From: Aubrey, Jamie
Sent: Tuesday, September 24, 2024 4:46 PM
To: Tom Maloney
Cc: Enstrom, Erik; Prater, Jacob; Condit, Kate; Mark Pendergraft; Kathryn Bird; Emily Morgan; Tom Abbott; Brian Merkley
Subject: RE: West Magnolia (FKA East Sunnyside) - Final Plat TR1, PA22-033

I've been bugging Brian about his comment letters for two (2) different plats that are concurrently in final plat review. This email pertains *only* to West Magnolia (FKA East Sunnyside) - Final Plat TR1, PA22-033. There is a

WEST MAGNOLIA

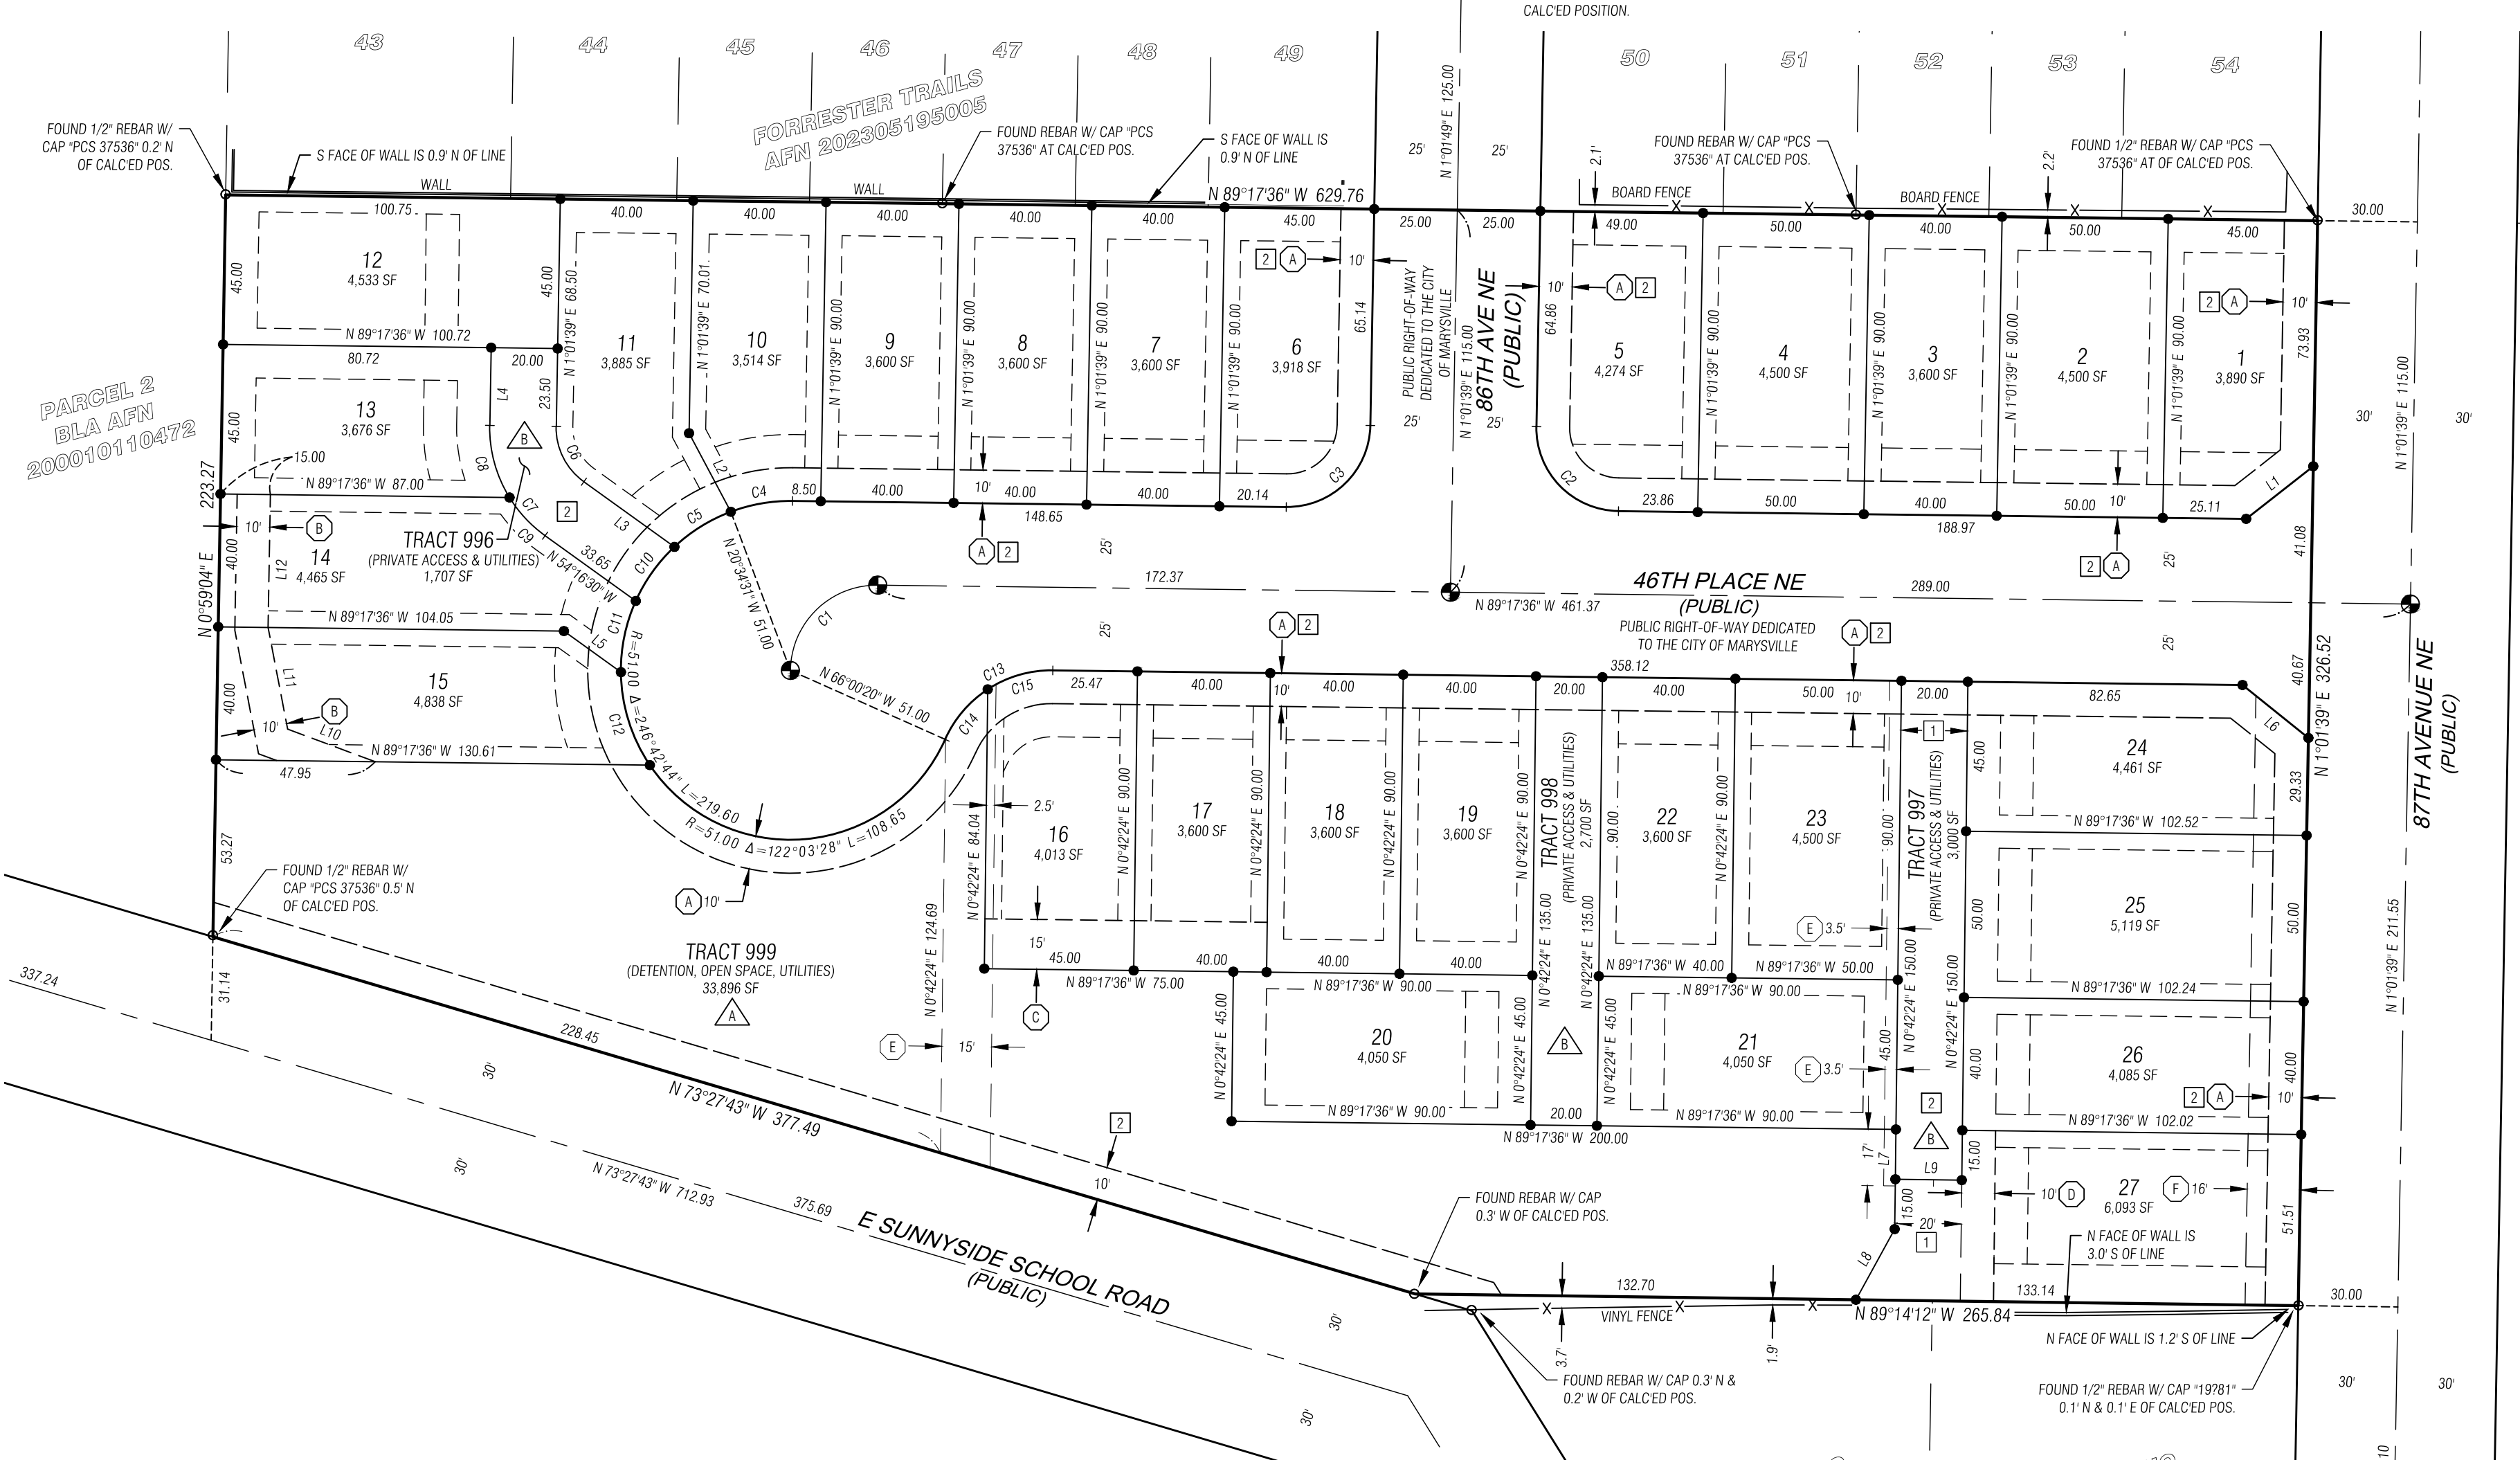
1. In regard to Lots 26 & 27, like Lots 24 & 25, it is our understanding that fire sprinklers are not required as the homes on these lots front the 87th Ave NE ROW and the distance from the ROW to furthest portion of the homes is less than 200 feet. Do you concur that fire sprinklers are not needed on Lots 26 & 27?

2. In regard to Lots 20 & 21, it is our understanding that fire sprinklers are not required as the distance from the furthest portion of the homes to the ROW is less than 200 feet. Do you concur that fire sprinklers are not needed on Lots 20 & 21?

1. For lots 26 & 27, the homes on Lots 24 – 26 will front 87th Ave NE. The house addresses will be on 87th Ave NE. Tract 997 serve as rear vehicle access (and will have “No Parking - fire Lane” signs posted). Because they front 87th Ave NE, we understand that these lots do not require fire sprinklers. Will you please confirm?

2. Lots 20 & 21 are accessed by Tract 998 with a hammerhead that extends across Tract 999 (and will have “No Parking - fire Lane” signs posted). Because of the hammerhead, we understand that these lots do not require fire sprinklers. Will you please confirm?

Thank you and I believe I have already talk to someone about this project. The lots on 87th do not need fire sprinklers as they are being addressed off of 87th. If they get addressed off of the auto court than access becomes an issue and they will require fire sprinklers.

Lots 20 and 21 will require fire sprinklers because of access and distance. Your measurements are not to the furthest point for the hose deployment and again access is an issue. While there is required signage parking will still occur and it will not be enforced because homeowners do not turn each other in.

As stated last week, these four lots will require fire sprinklers due the distance from ROW to furthest portion of the homes being greater than 200 feet. If you have any further questions on this matter, please direct them to Fire Marshal Tom Maloney (cc'd).
